Site 67 – State Significant Development (SSD) 6246 MOD 2 – SOPA Consent

It is noted that the application seeks to modify the height of the buildings in accordance with the levels of new roads 3 & 4. SOPA has reviewed the documents and notes the following matters are raised for your consideration. It should be noted that these matters may be raised when the consent authority seeks comment from SOPA regarding the proposal.

Scale: 1:50 @ A1
 Date: 11/09/15
 Project No: 13056
 Drawing No: A-SSD-310-003

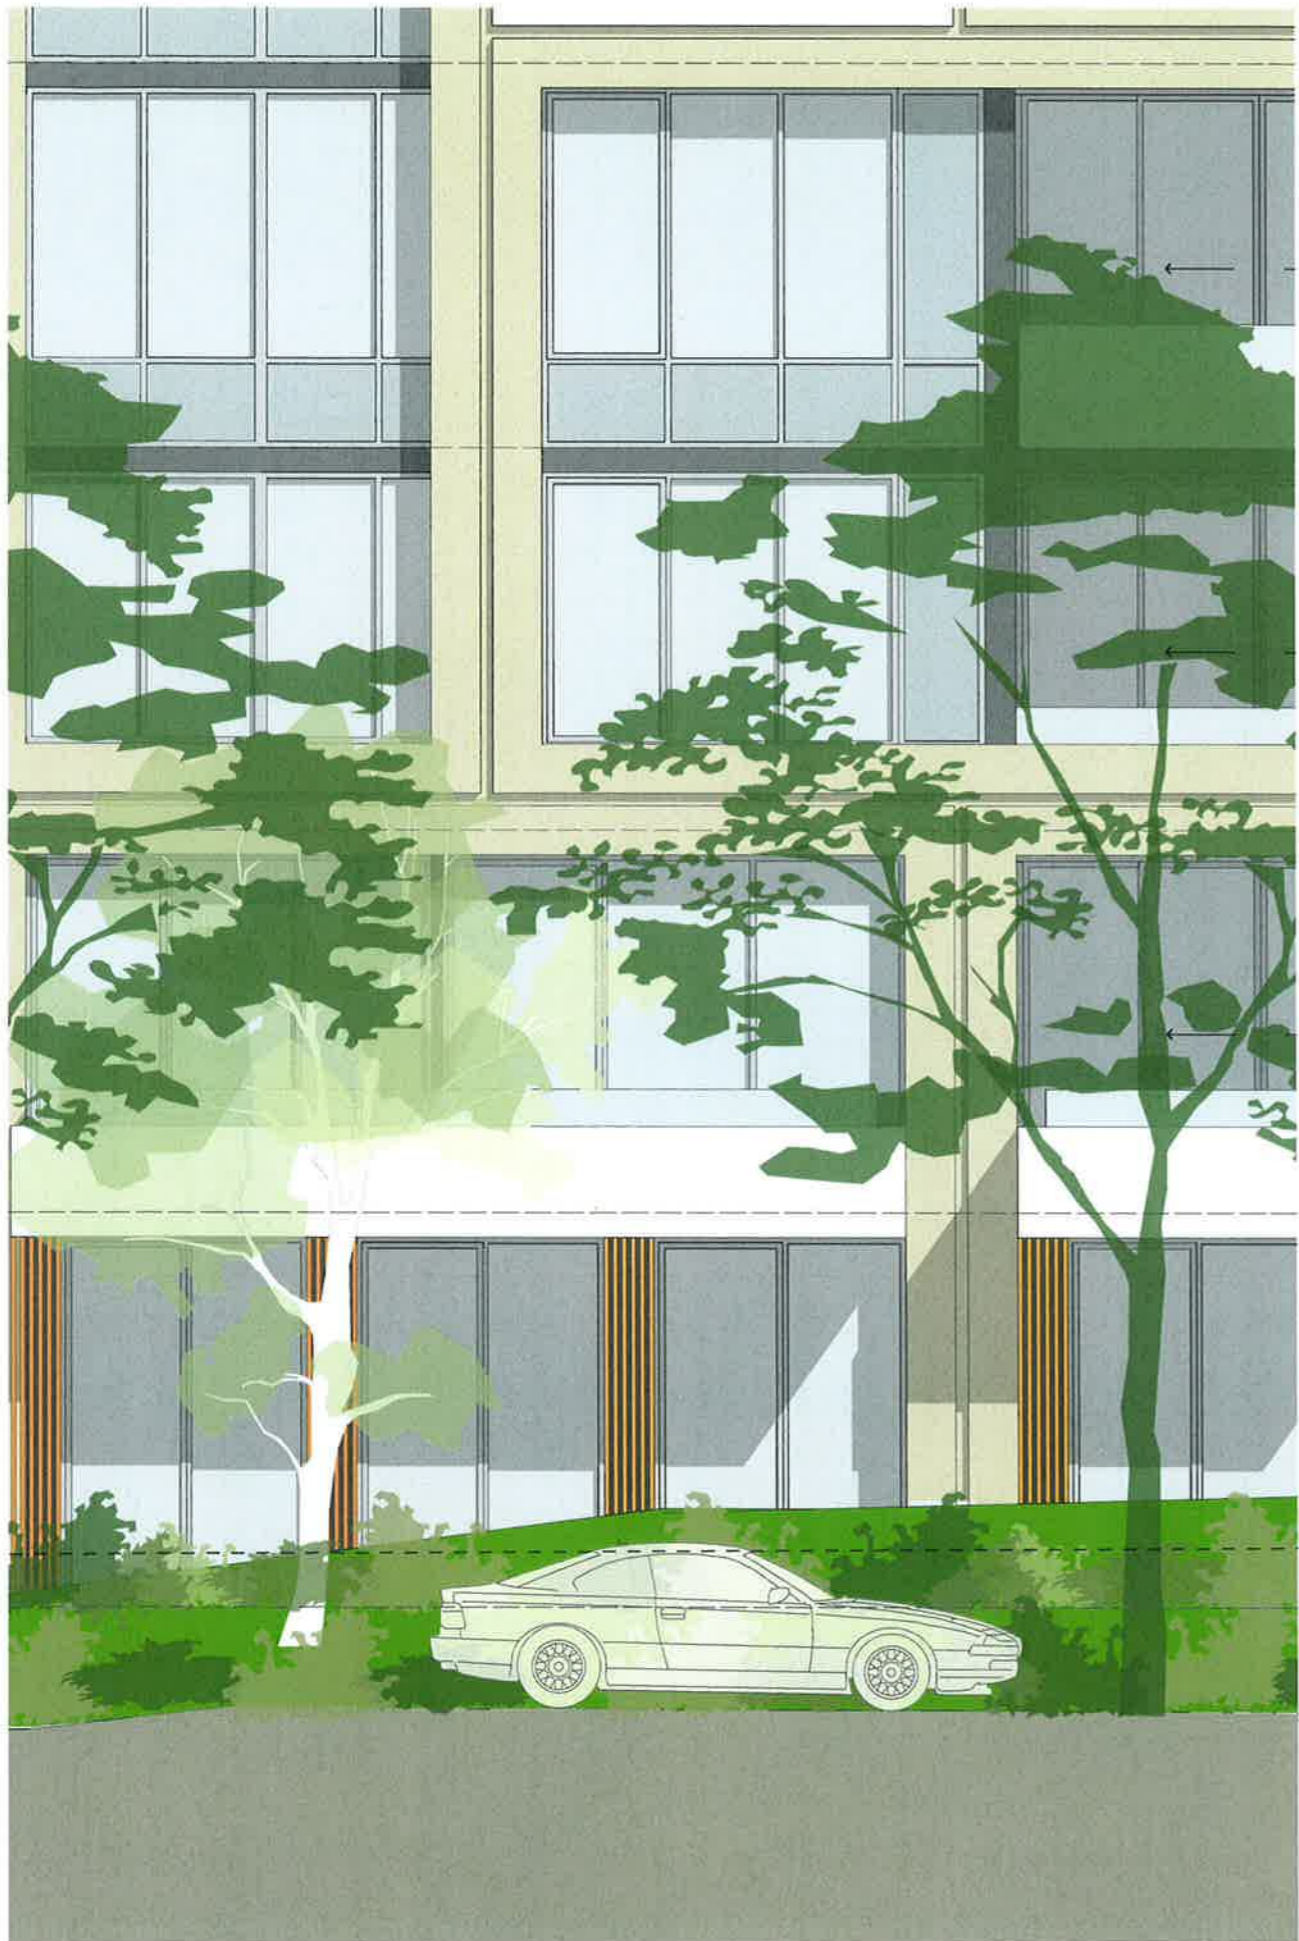
Turner Architect's modified cross sections cut through ground level apartments with frontage to 'New Road 4', and indicate variable height/width and sloped planted treatments which interface onto public footpaths. These are noted in the following plans:

- ASSD-664 310-003 Rev F
- ASSD-664 310-004 Rev E
- ASSD-664 310-005 Rev E
- ASSD-664 310-006 Rev E

Heights of proposed planting beds are noted as varying between 150-700mm with variable widths of 1.45m-4.8m

Steeper embankment slopes shown in the architectural cross sections would result in mulch and plant litter spilling onto footpaths creating an unacceptable slip risk for pedestrians and ongoing public domain management liability for SOPA. Dwarf retaining walls are recommended where mass planted slopes exceed a gradient of 1:3.

Rev	Desc	Appr'd By	Number/Date	Drawn By	Scale
1	ISSUE		13056	MP	
2	REVISED		A-SSD-310-004	E

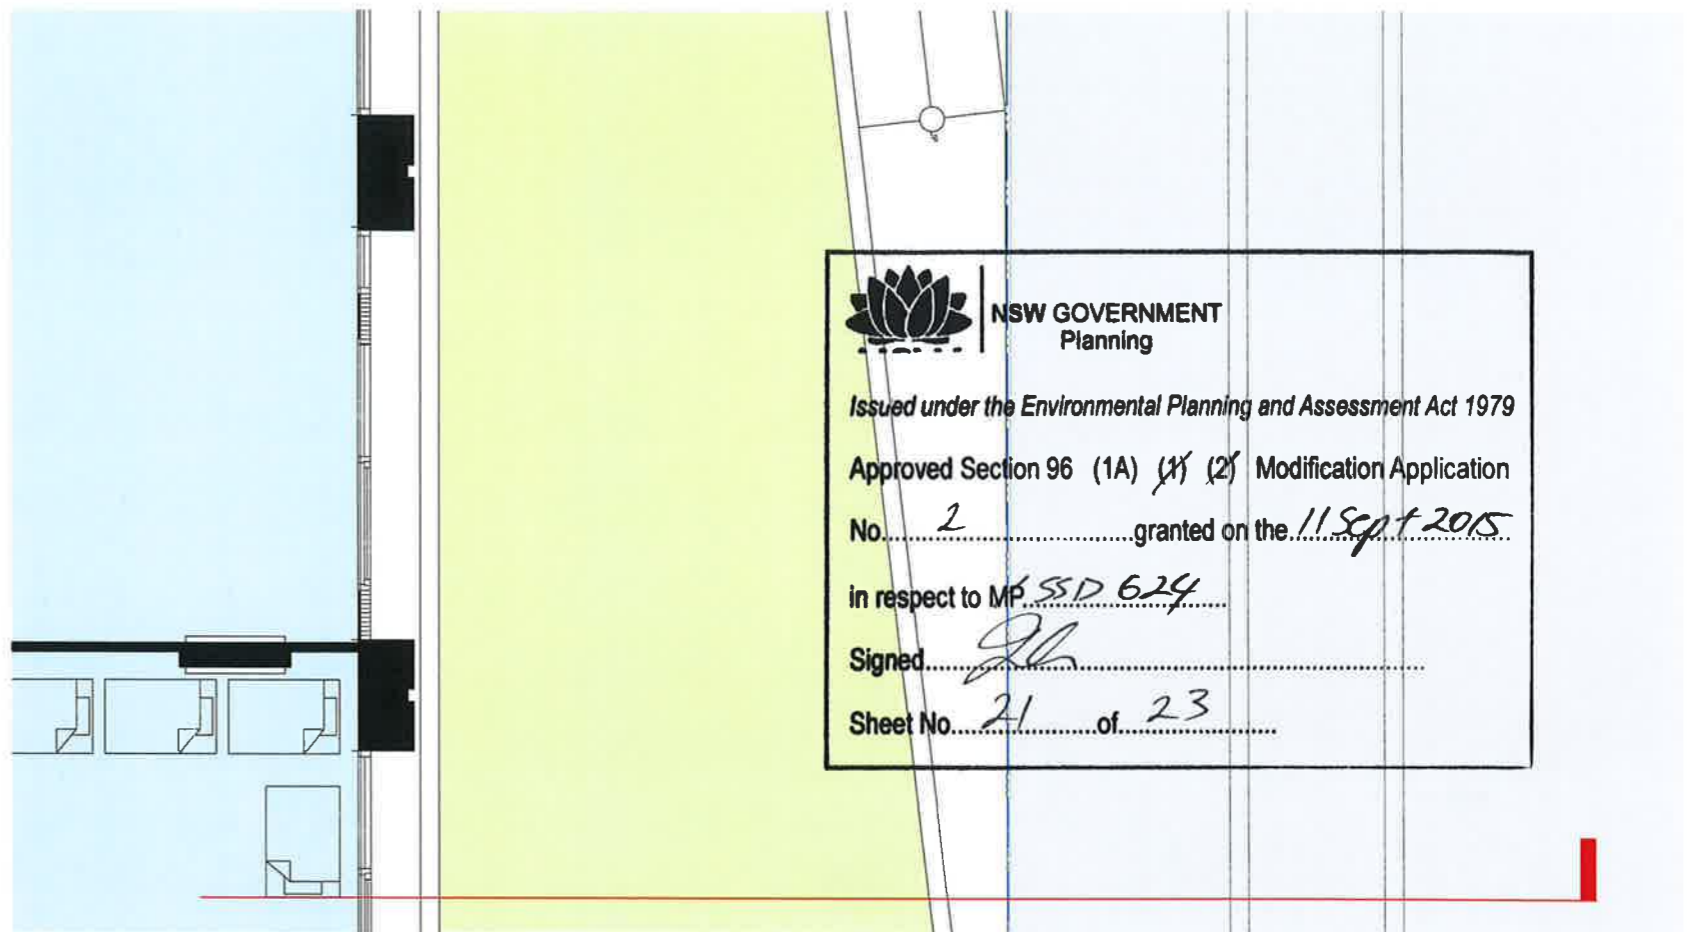
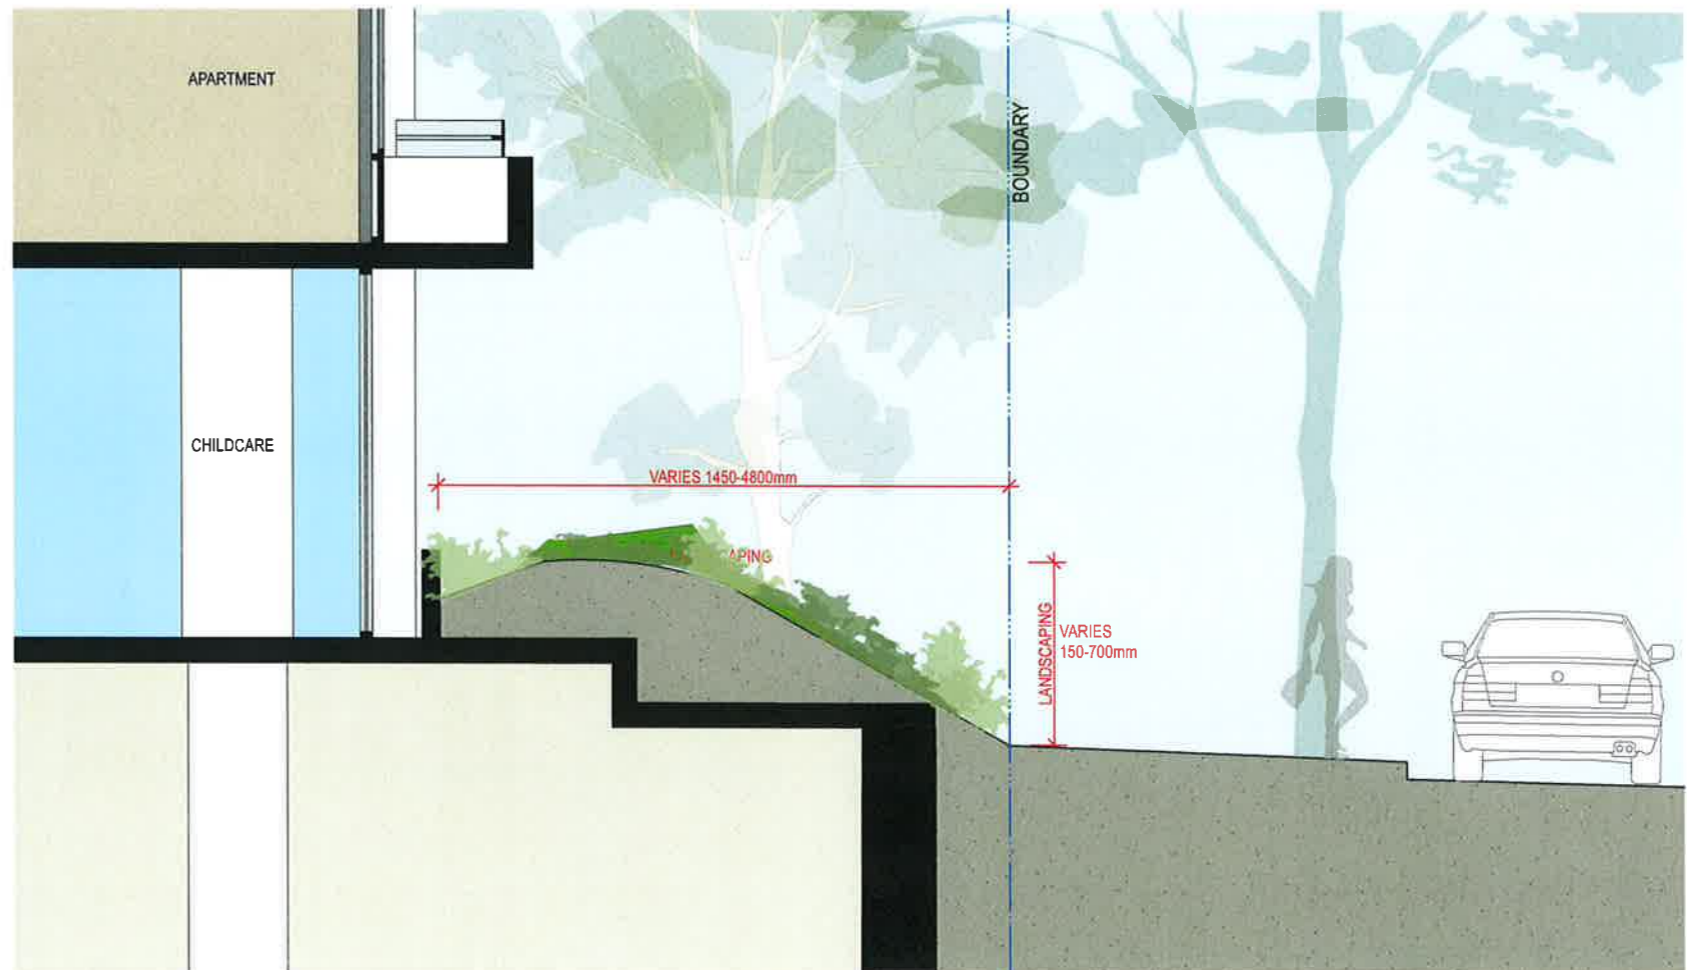
Medium to large scale trees (shown in plans ASSD-664 310-004 Rev E and ASSD-664 310-005 Rev E) are also shown growing in shallow depths over suspended slab which would not provide adequate 'rootable soil volume' to sustain trees of this size.

Dwarf retaining walls may also provide an opportunity to retain additional volumes of soil for supporting courtyard trees shown over slab slabs
